**20240514-ABP-319397**

**Ref. 319397**

**For: Substitute consent for quarry and ancillary precast concrete manufacturing yard**

**Site: Tromman Quarry, Tromman, Rathmolyon, Co. Meath.**

Figure 6. EPA mapping showing the local surface water network in relation to the quarry site (location denoted by red cross). The River Boyne and River Blackwater SAC is illustrated by the orange / brown colour. Source of the map and waterbody names: EPA⁹.

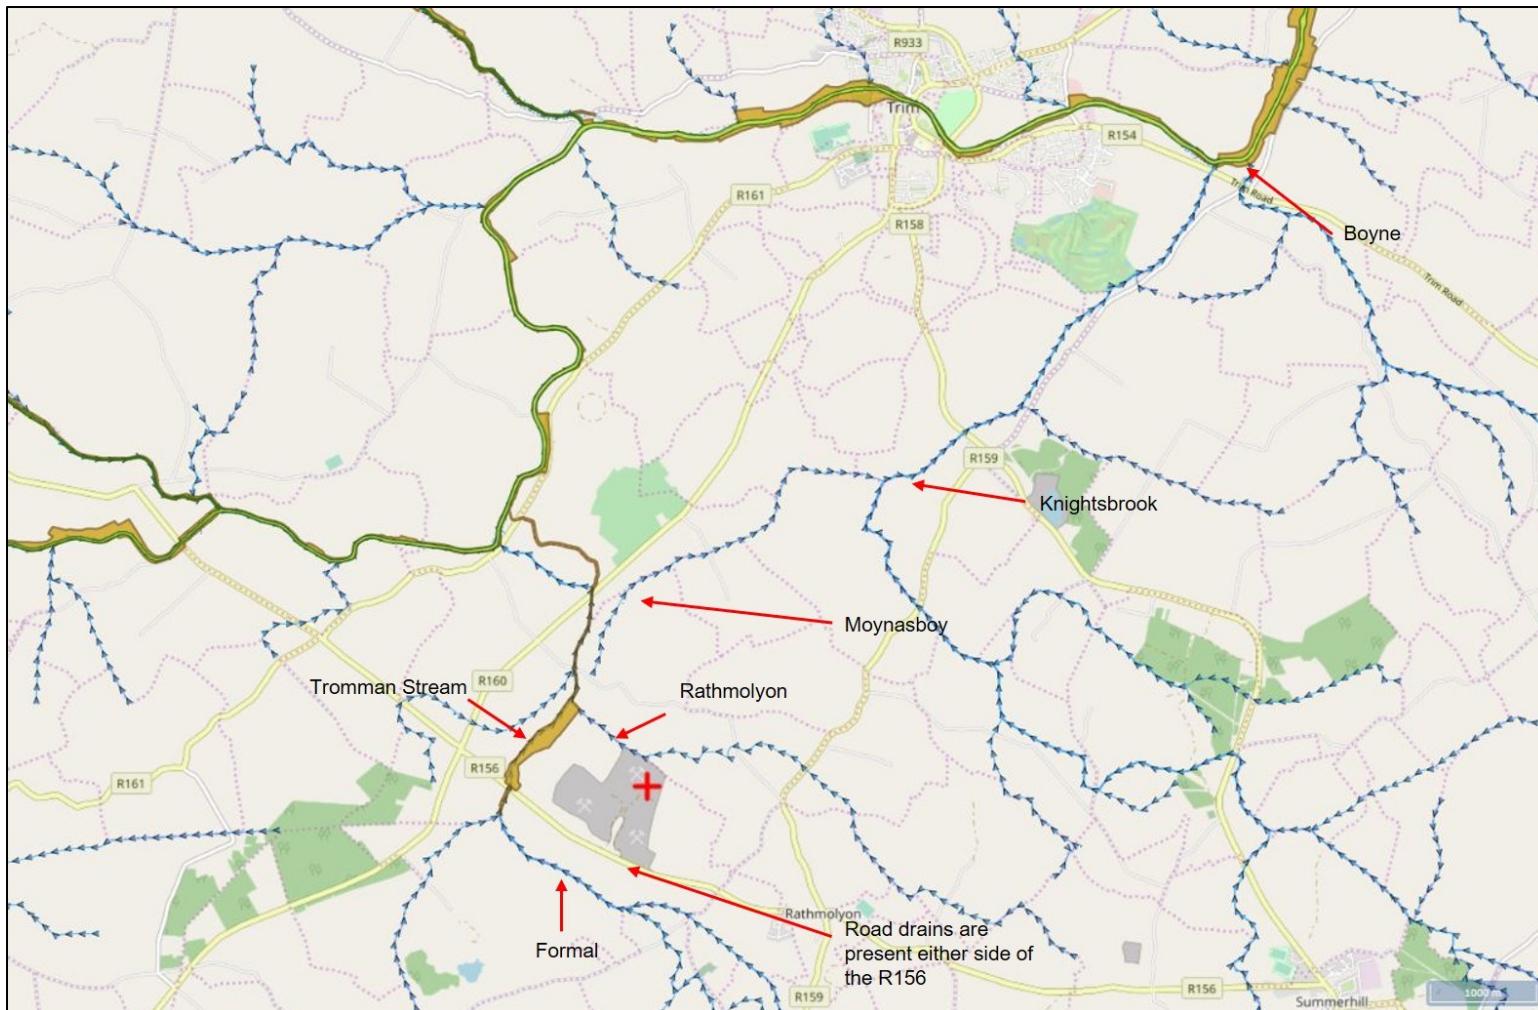
We note that in the context of the rNIS a great deal of weight rests upon the hydrological connection between the streams which run along the south of the site (Tromman stream) and the one that runs along the northwest of the site (Rathmoylan stream). The former being directly linked to the River Boyne and Blackwater SAC. The applicant appears to rely on a one-day site study, as outlined on page 10 of the hydrological report, for evidence that the two waterbodies do not meet. Section 4.1 of the rNIS outlines:

Table 2 in the rNIS clearly elucidated the risks posed to the Natura site in the screening exercise, with water quality risks as a result of the unauthorised development and ongoing quarrying activity. The rNIS screening outlines that EPA mapping showed the hydrological link with the SAC to be immediately north-west of the site, via the Rathmolyon Stream flowing into the Tromman Stream, which is designated as an SAC along this section. From the bolded text above, and cross referencing with Table 4 it is clear that the risk outlined in the rNIS screening in regard to impact on the SAC at this geographical point is not being considered further on foot of their one day survey which found no hydrological connection. We have cross referenced the map presented as Reference 12 (Figure 1) in the hydrological report with other open source mapping tools (Figure 2-4). This lack of convergence of the two waterbodies is not evident on the other online mapping tools we consulted. Given that this is one of the primary pieces of evidence relied on to rule out potential impact on the River Boyne SAC we submit that it is vital that more rigorous evidence is sought on this, given this is a key point for the rNIS. A long-term hydrological survey, including during prolonged wet periods, is necessary to establish the hydrological connection, or lack thereof, before a decision is made. As stands, we submit that this does not meet the threshold of beyond reasonable scientific doubt, and the Board should seek further clarification on this important point.
